Thank you for the opportunity to review and provide comments on the Open Water Surf Facility Modification Application to SSD-7942. In particular I welcome this opportunity because we weren't able to provide comments on the first application.

In regard to Sec 6.7 Water Quality in the Statement of Support for Section 4.55(2) Modification Application to SSD-7942 - the proponent will need to ensure that the facilities located within the surf park are designed so that they can be maintained in accordance with the Public Health Act 2010 and Regulation 2012 requirements for public swimming pools. Water chemistry and disinfection requirements for public swimming pools are listed in Schedule 1 of the Public Health Regulation 2012.

1 DETAIL PLAN POOL AREA
SCALE 1:100

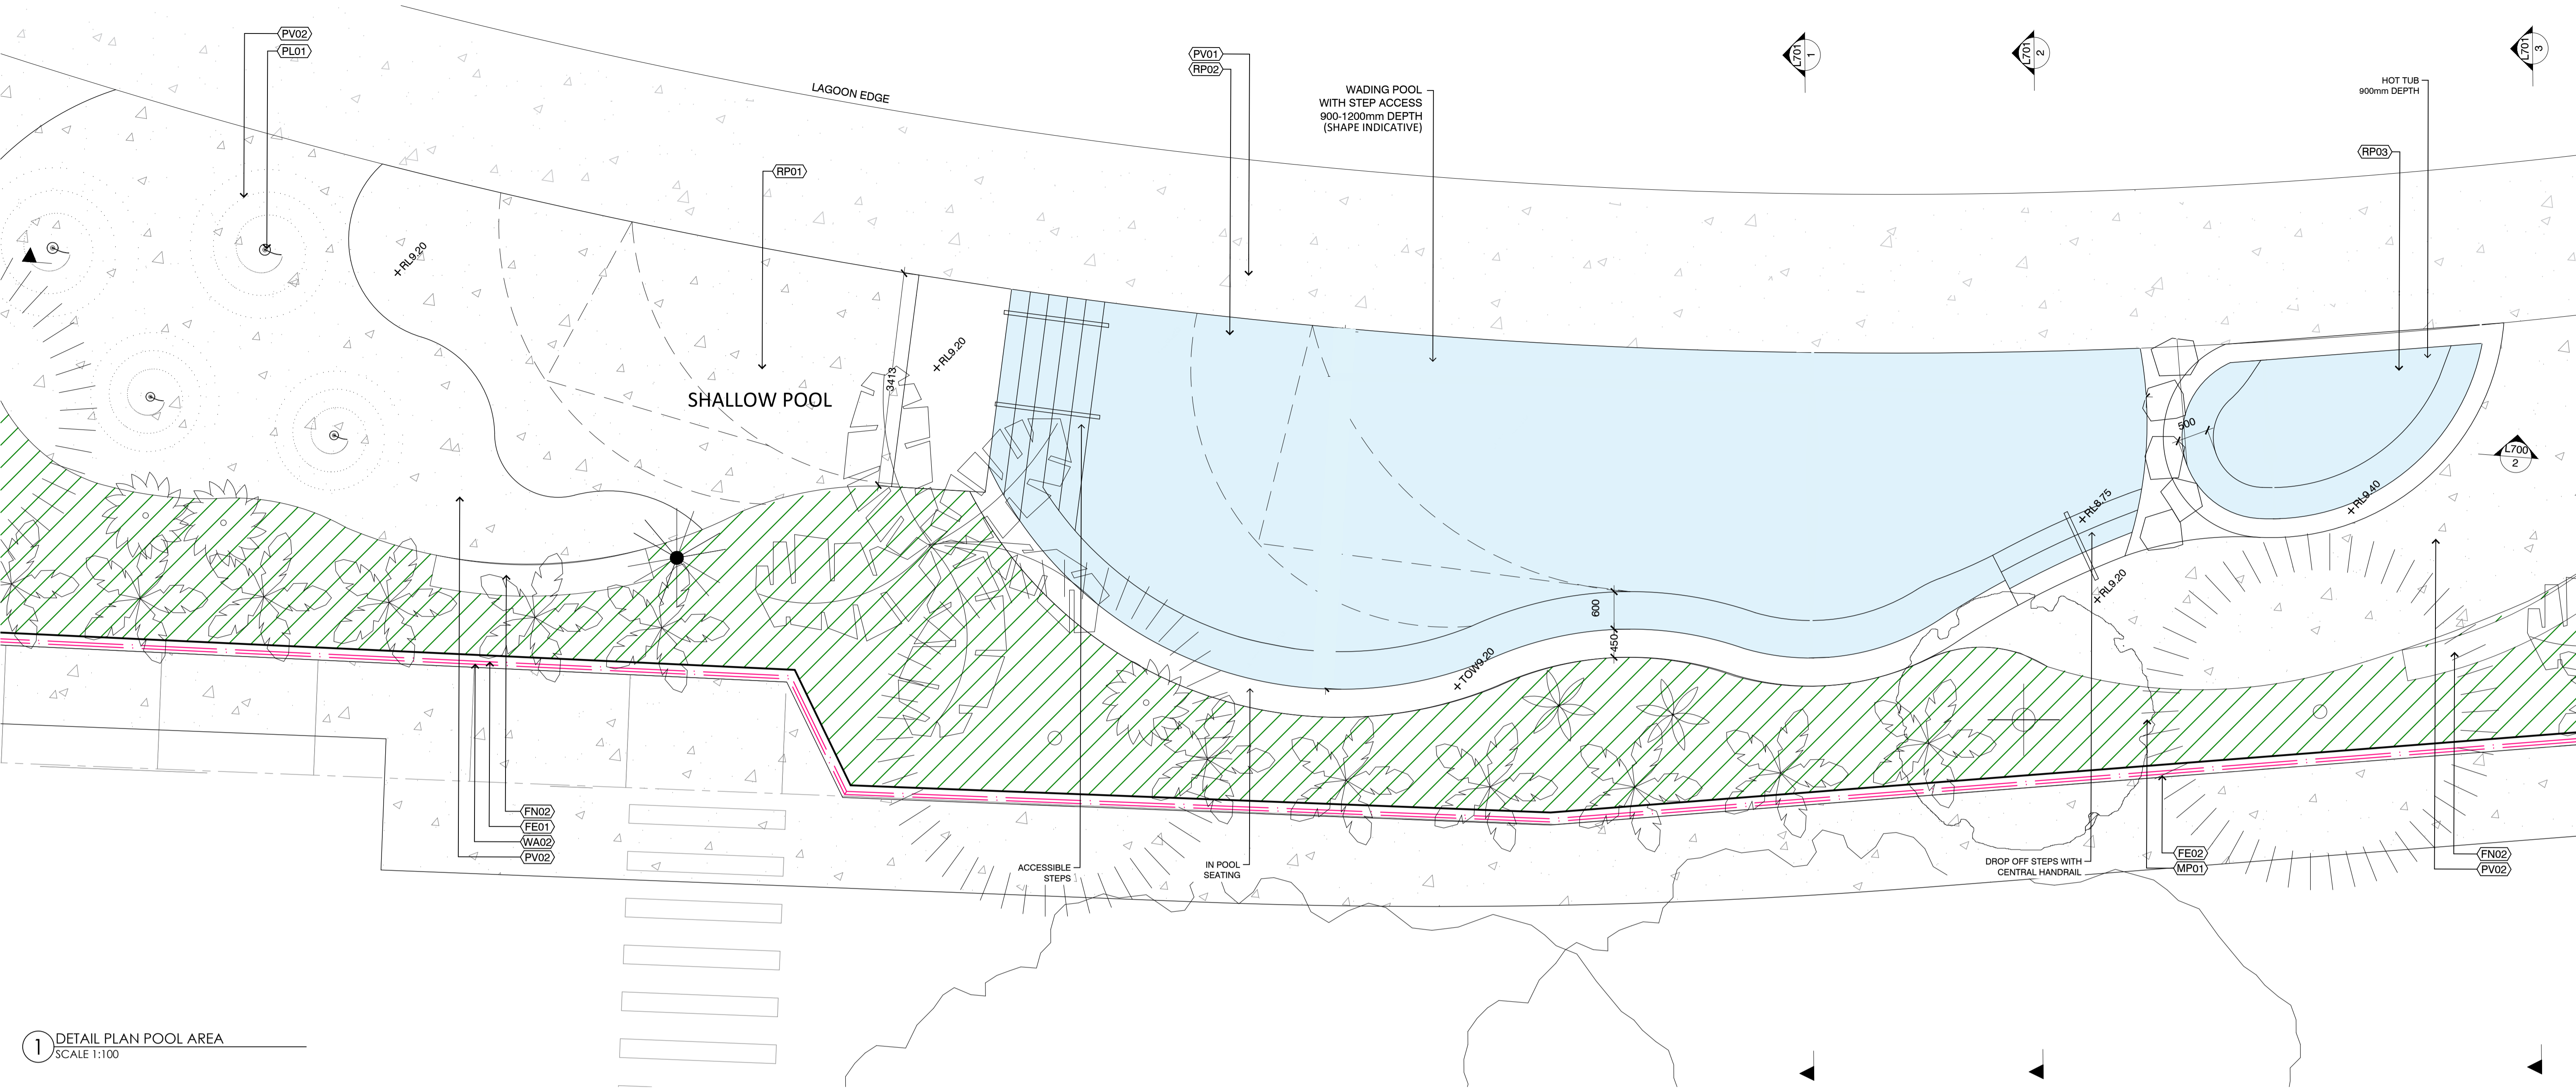
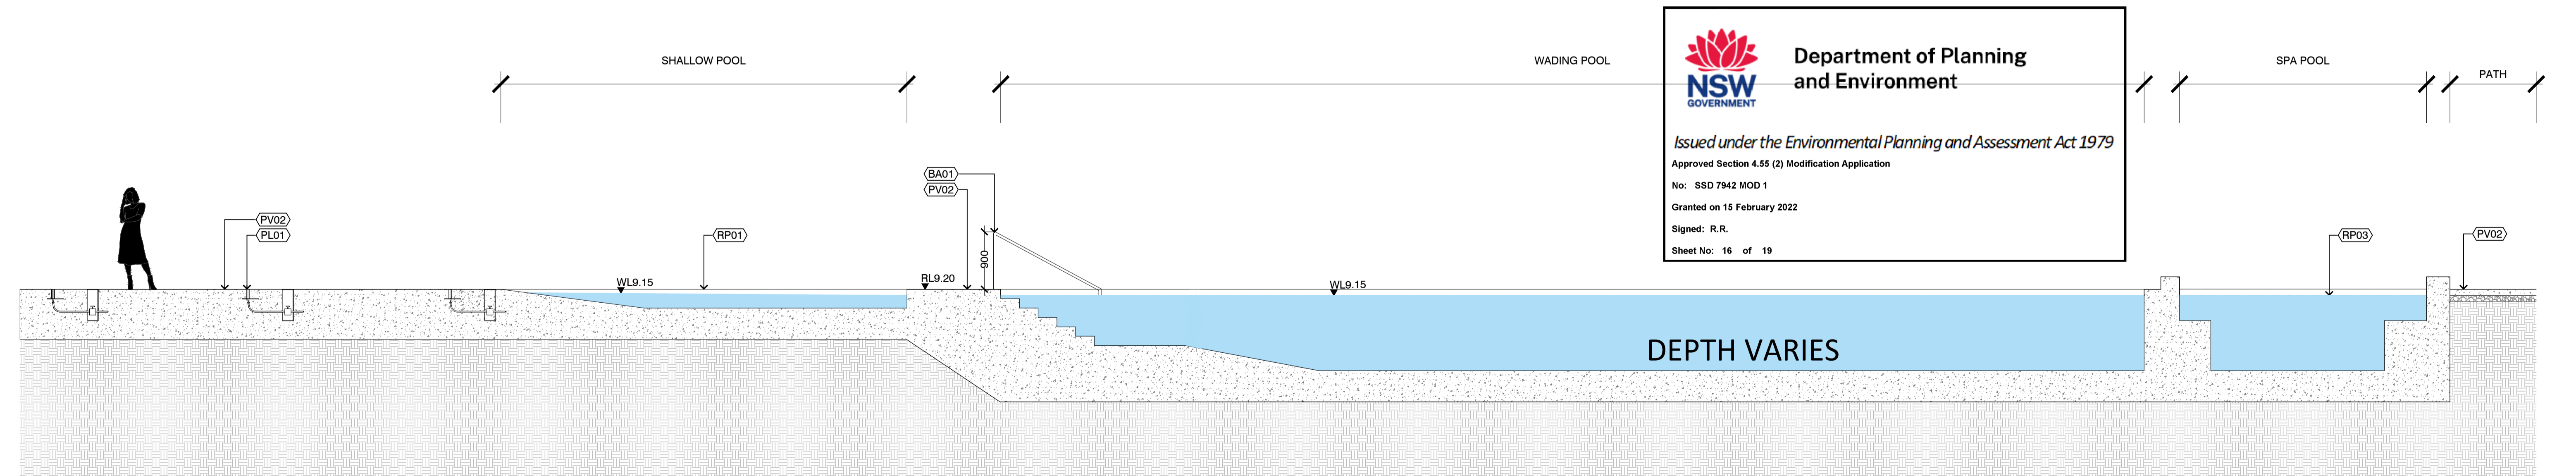
These requirements are extended not just to the wave pool lagoon but also to the rock pool (dependent on design/depth/water source), toddler pool, hot tub and splash zone along the south-eastern edge of the lagoon beach (as mentioned in 3.1.3 Modifications to the Lagoon and adjacent facilities.

It is strongly recommended that each 'pool' has its own separate circulation and disinfection system and that there is a connection to sewer for disposal of backwash water or other waste water in accordance with Sydney Water trade waste requirements.
